**CITY OF ALBUQUERQUE
PLANNING DEPARTMENT**

January 29, 2014

DRB Comments

RE: Tracts 127 & 130 MRGCD Map #35

T10N R2E SEC. 12

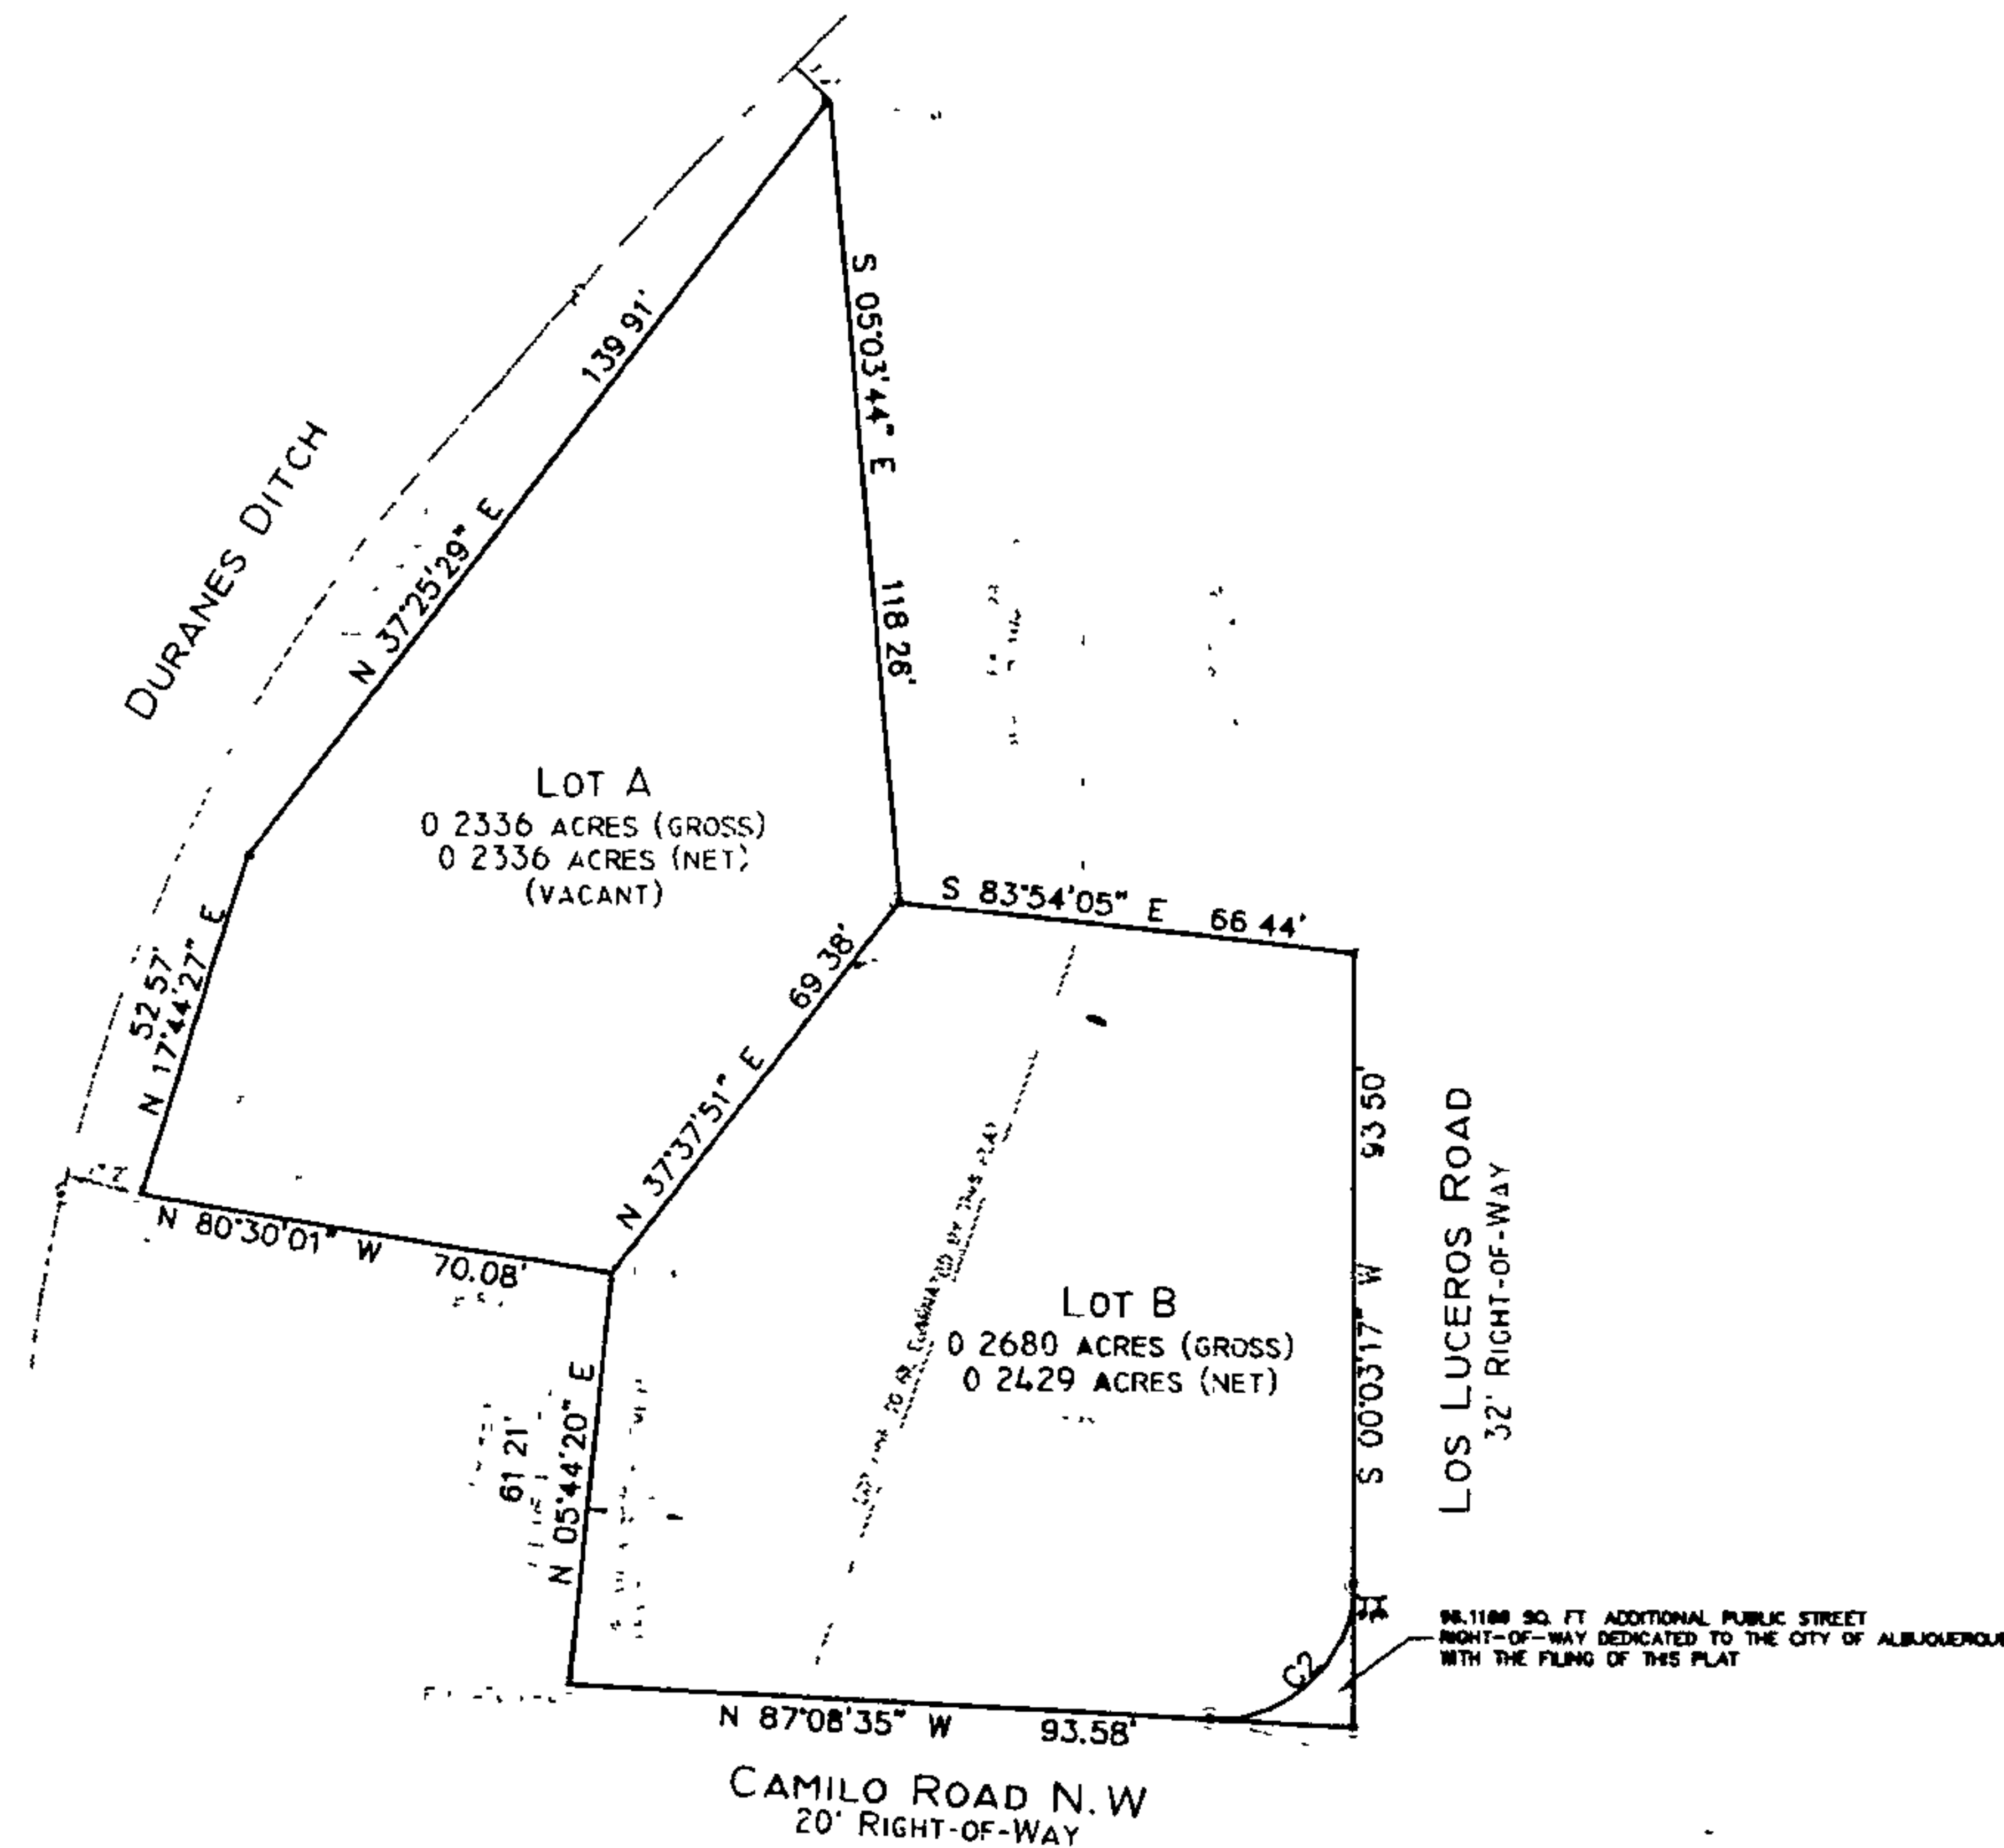
The minimum required easement off Los Luceros to provide private access and private utilities for 2903A Camillo LN and proposed rear lot is 22 feet; utilities might also be available from Camillo – refer to comments from ABCWUA.

It will need to be demonstrated that the proposed rear lot is buildable with a 22 foot easement running through the middle – it is recommended to contact Zoning Enforcement regarding required setbacks and how large a building footprint is possible.
